SPACE VILLAGE APARTMENTS SITE DEVELOPMENT PLAN

Space Village Apartments
VARIANCE SITE PLAN
Colorado Springs, CO

VARIANCE
SITE PLAN
V1

SPACE VILLAGE APARTMENTS
SITE DEVELOPMENT PLAN

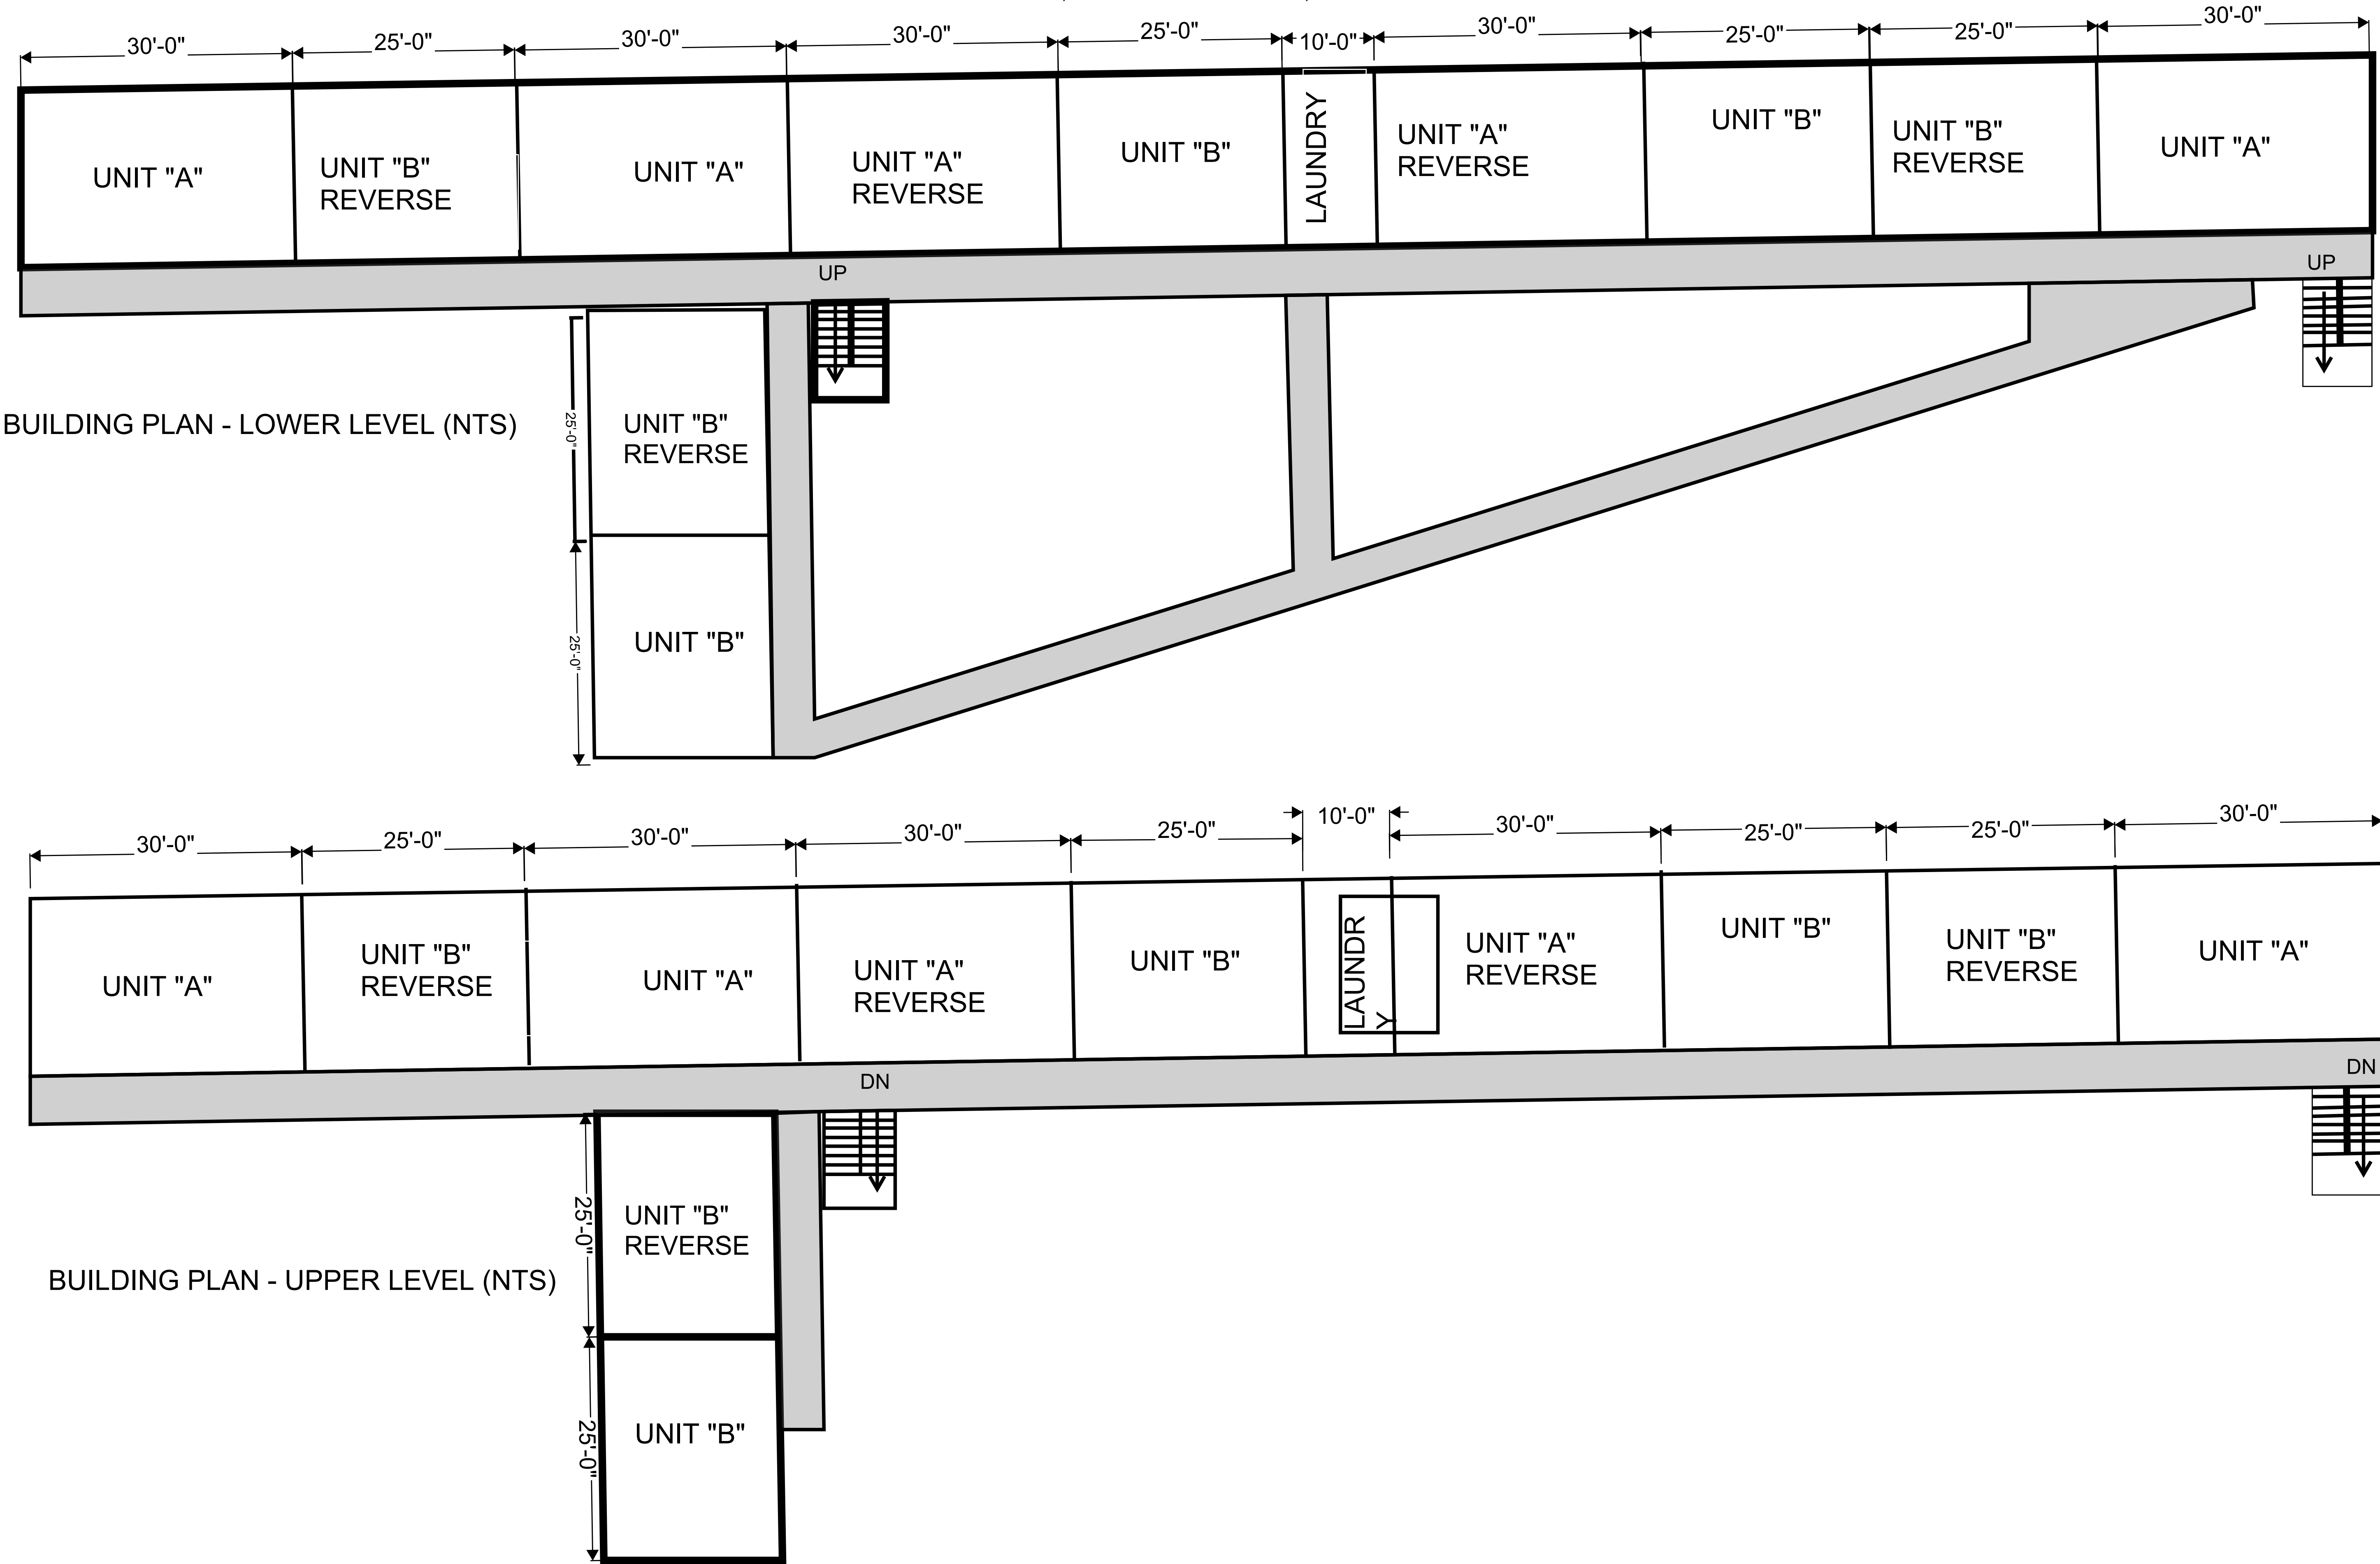
please add a north arrow

add all symbology to a legend

Need to see:
 -The layout and location of all landscaping, including landscape setbacks
 -all vegetation/landscaping needs to be tabulated and dimensioned so we can verify what is being provided vs. what the code requires.
